CITY OF ALBUQUERQUE

RE: CIELO LINDO SUBDIVISION (M-11/D5)
Engineers Certification for Release of Financial Guaranty
Engineers Stamp dated 12/06/2004
Engineers Certification dated 04/27/2006

RE: FINAL CERTIFICATION OF GRADING AND DRAINAGE FOR CIELO LINDO
SUBDIVISION (M11/D5)

RE: GRADING AND DRAINAGE PLAN FOR CEILO LINDO SUBDIVISION (M11/D5)

### ORIFICE PLATE DETAIL

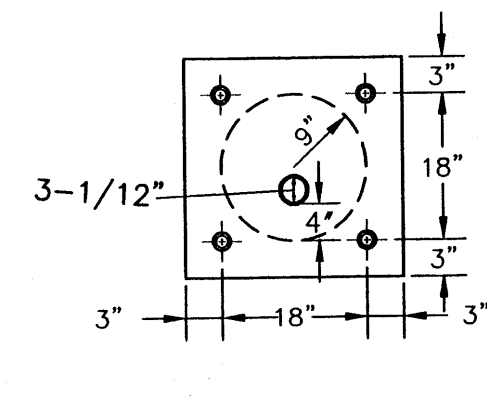
I have reviewed the drainage report for the subject project and the following are my comments. Advanced Engineering and Consulting, LLC is the design consultant for the project. They have proposed to move the existing detention pond that serves the Puno De Tierra Subdivision and relocate it to the east end of Ceilo Lindo Subdivision. The pond will then discharge to a drop inlet on Coors Boulevard at a discharge rate of 0.73 cfs. Currently, the discharge to Coors Boulevard is approximately 14 CFS, so the proposal will improve the drainage condition on Coors. This design is acceptable.

### CONCRETE SWALE DETAIL

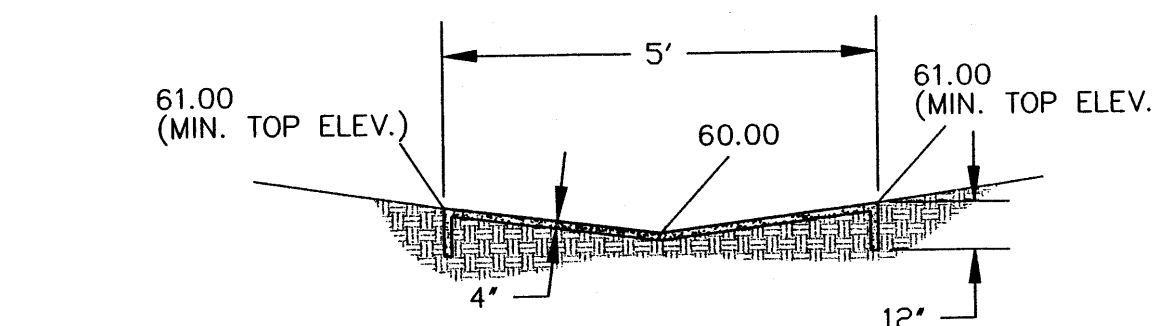
- The concrete channel in the cul-de-sac should be sized for developed runoff. Please revise your calculation accordingly.
- I'm not sure how you analyze the capacity of your inlet. The head (H) available at a type "C" or "A" inlet is at best 10 inches, not 1.25 feet as you have shown. Please revise or show a detail how this is possible.
- The pond is proposed for public maintenance. Please coordinate with Storm Drain Maintenance for any comments on the configuration of this pond.

- 1) The concrete channel in the cul-de-sac did not have to be revised for the developed runoff, but the drainage opening at the wall was increased to handle the developed runoff of 5.53 cfs. See the revised grading plan for the changes. Also see attached AHYMO runoff results for the developed conditions using the following treatments: B=33%, C=17%, & D=50%.
- 2) We modify our inlet calculation using a 10" maximum water depth at the inlets. See attached calculations.
- 3) We talked with Glen Jurgensen regarding the access for the pond and he said there should not be any problem with the way we have shown the access for the maintenance of the pond.

Wall Opening = 2.00'

$Q = 6.25$ cfs > 5.53 cfs
